From: Laura Gibbons <Laura.Gibbons@arun.gov.uk>
Sent: 28 May 2021 13:19
To: Planning.Responses <Planning.Responses@arun.gov.uk>
Cc: Raymond Cole <Raymond.Cole@arun.gov.uk>
Subject: RE: Planning Consultation on: P/49/21/RES

Application No: P/49/21/RES
Registered: 31st March 2021
Site Address: Land North of Sefter Road & 80 Rose Green Road Pagham
Grid Reference: 490199 99587
Description of Works: Application for the approval of Reserved Matters pursuant to condition 1 (Reserved Matters details), condition 6 (Design Code Masterplan) & condition 7 (landscaping & layout details) following the grant of P/134/16/OUT for the erection of 250 No. dwellings, (including affordable homes), replacement scout hut, land for an Ambulance Community Response Post Facility, demolition of No. 80 Rose Green Road & provision of Public Open Spaces including associated children's play areas, landscaping, drainage & earthworks (resubmission following P/24/20/RES). This site also lies within the parish of Aldwick.

Drawing Title: Surface Water Drainage Strategy Layout

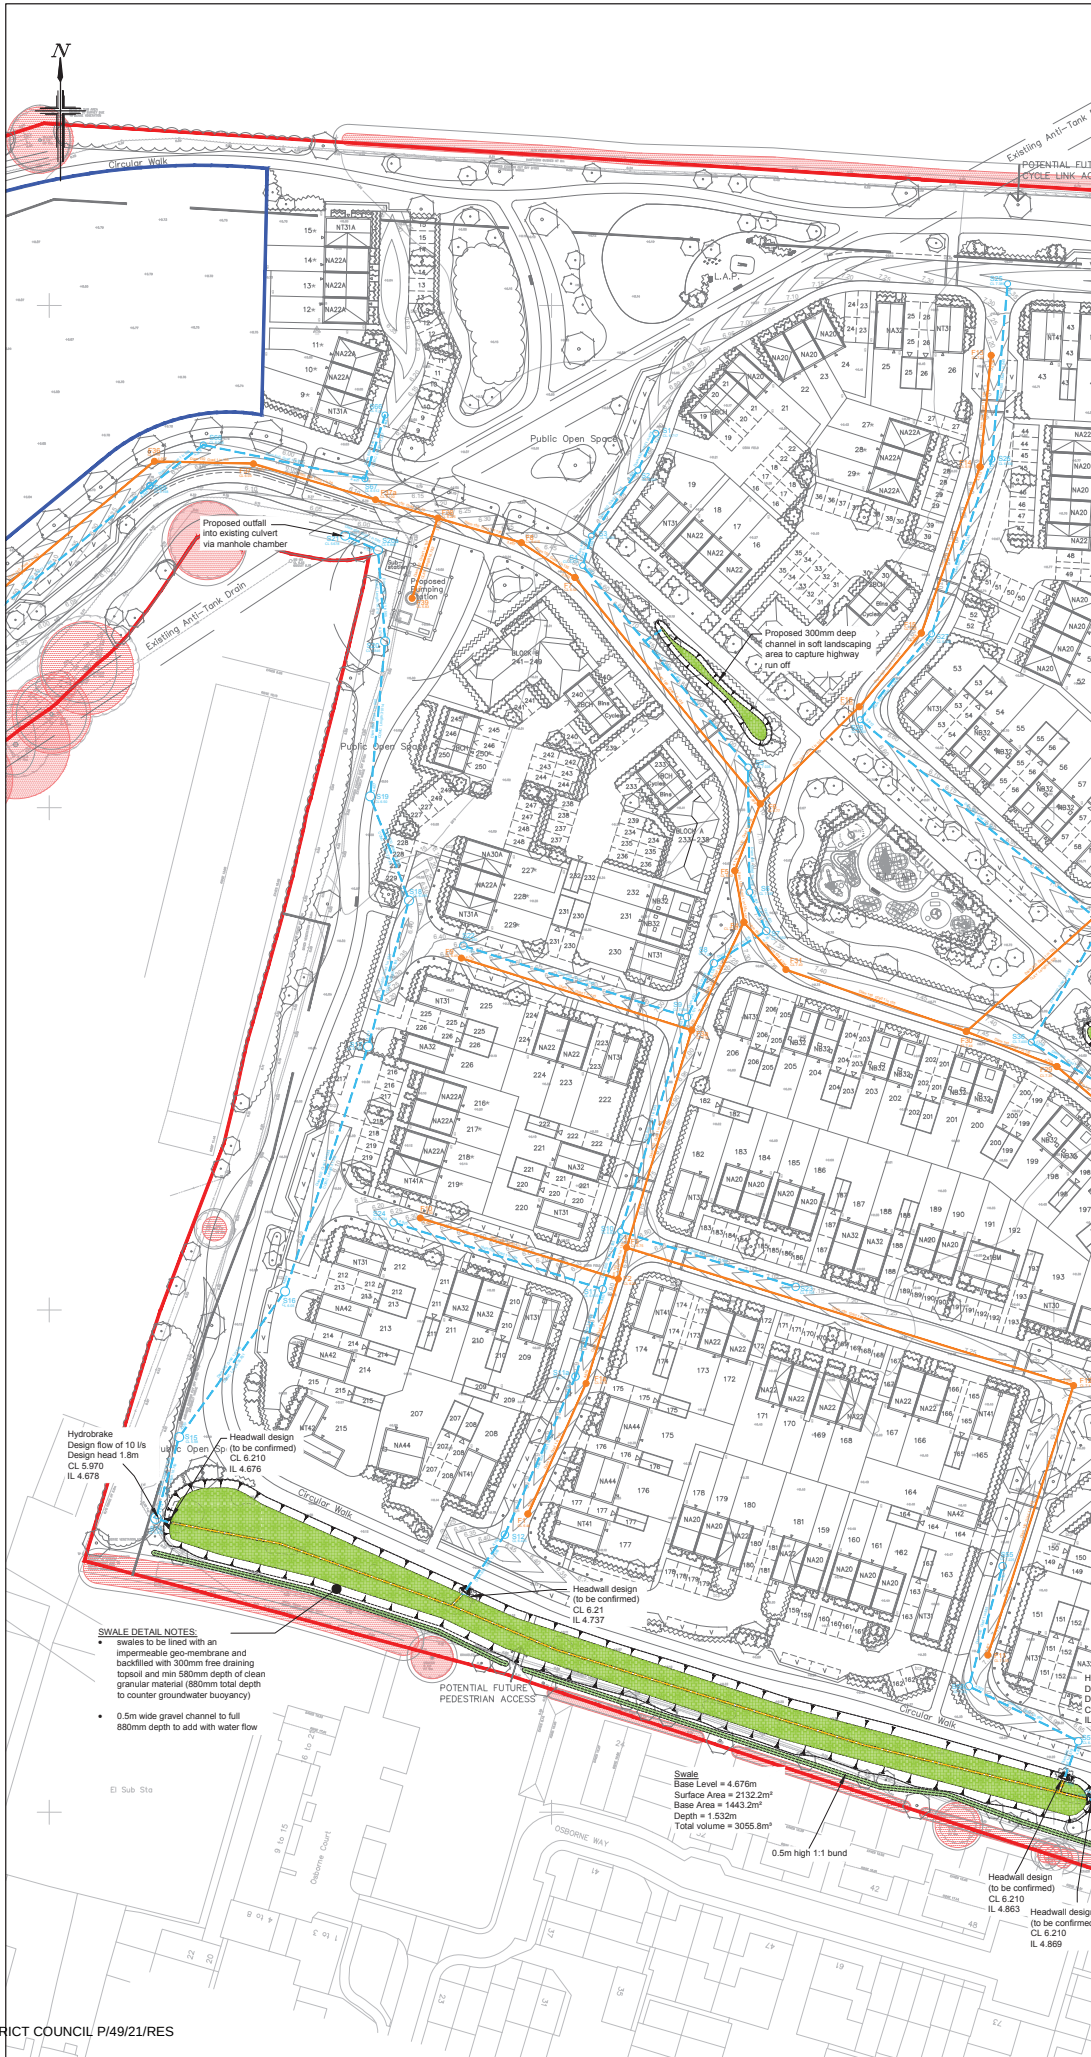
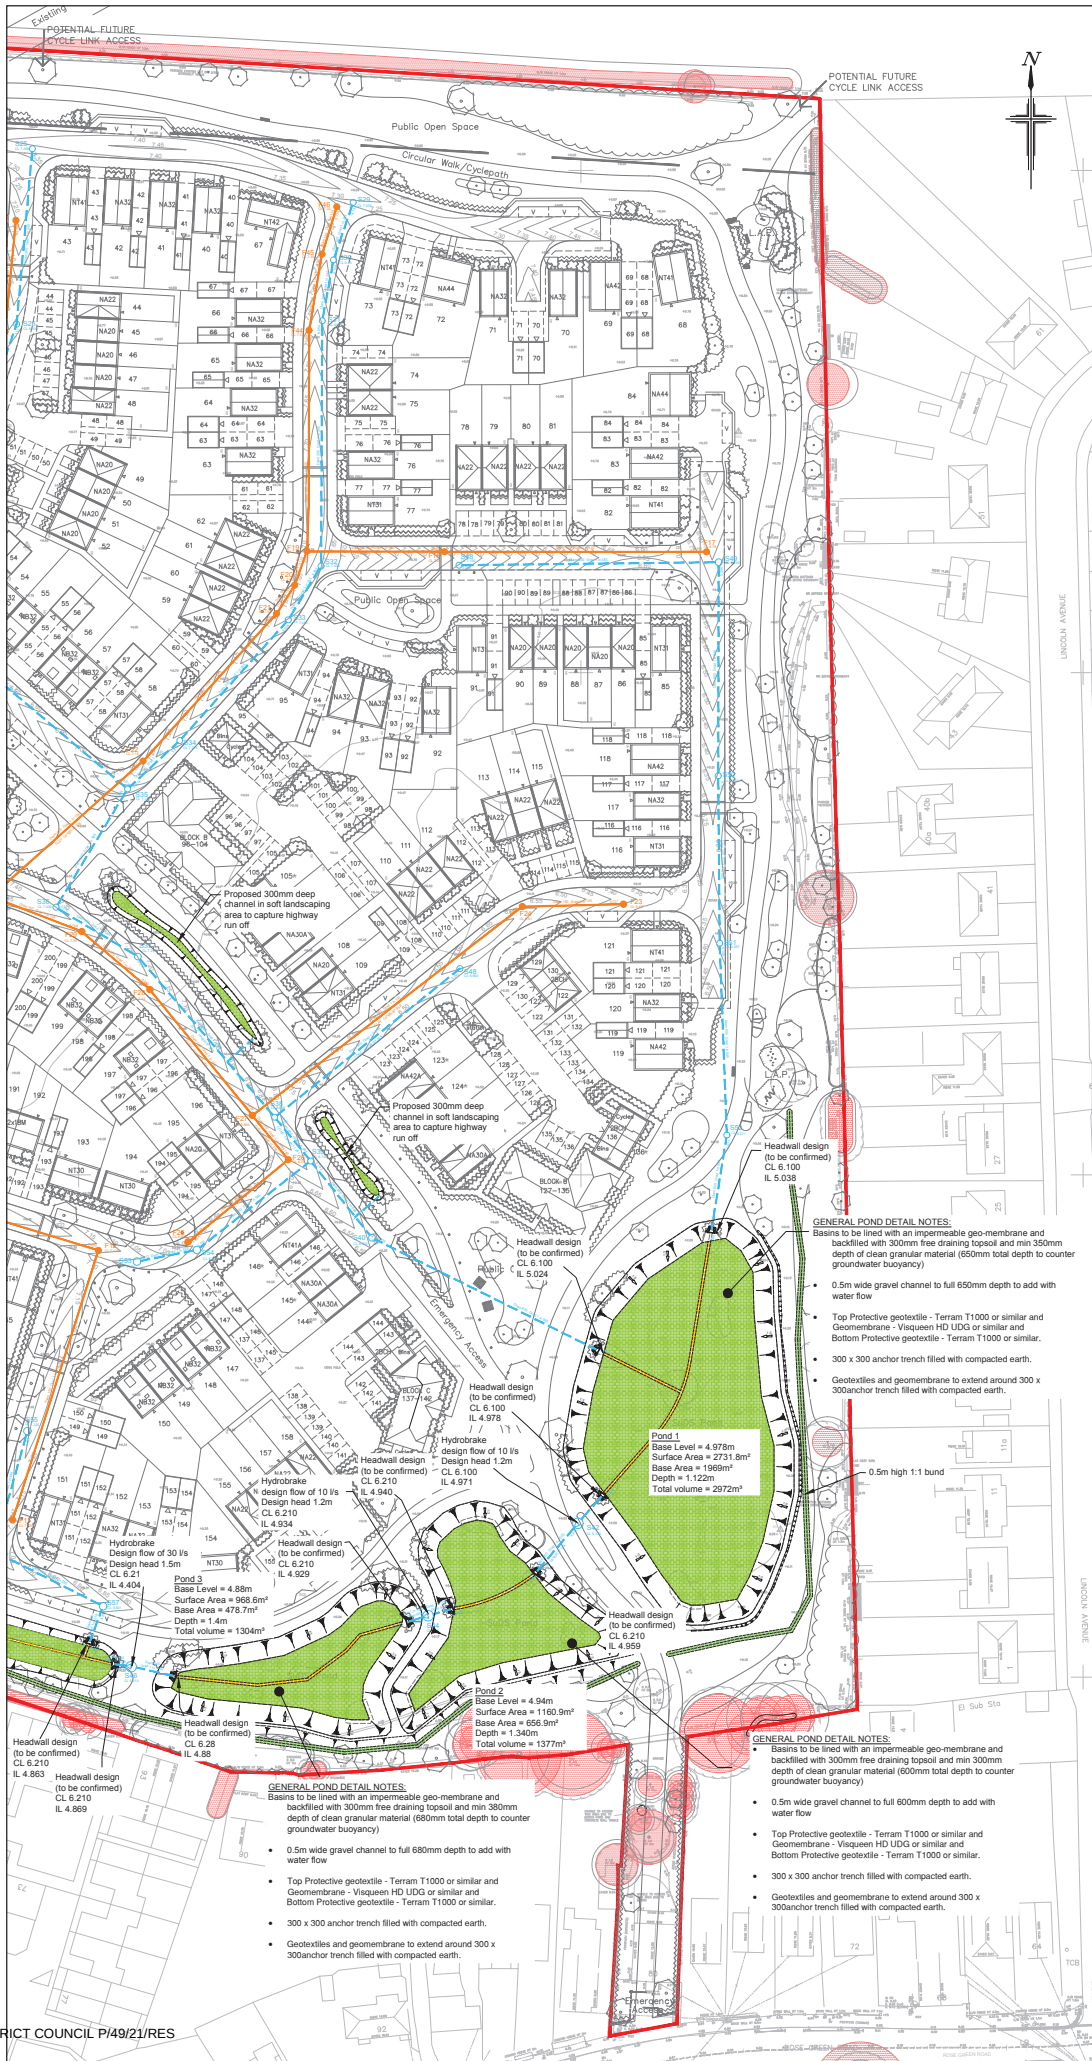
1. The total impermeable development area is reportedly 5.475Ha, QBar according to uk suds is 15.73l/s. It appears that discharge is proposed in two locations via 3 outfalls. The proposed discharge rates appear to be 10l/s, 3.5l/s and 5l/s. This in total is greater than the QBar rate. Please provide an impermeable areas plan, and QBar calculations for each catchment. Currently Q1 calculations are supplied.

2. Please make it clear on plans where points of discharge are. The eastern network appears to have a discrepancy on the label for S46. The leader indicates an I.L. of 4.4.04 but the actual network label indicates 4.872 which tallies with calcs. Without zooming in this does cause some confusion as it appears the network breaks its back based upon the leaders.

6. Please provide a manhole schedule printout for network 2 in microdrainage.
7. The leader for S79 indicates a discharge rate of 3.5l/s but in calculations this is 3l/s please ensure consistency.

8. There are inconsistencies between calculations and the layout for; the attenuation tank at S80, pond at S75, pond at S79. Please update.
9. Please provide printouts for storage inputs and hydrobrake for network 3.

12. We note that the watercourse around pond 4 is proposed to be diverted, we are concerned by how little distance there is between the pond and watercourse.
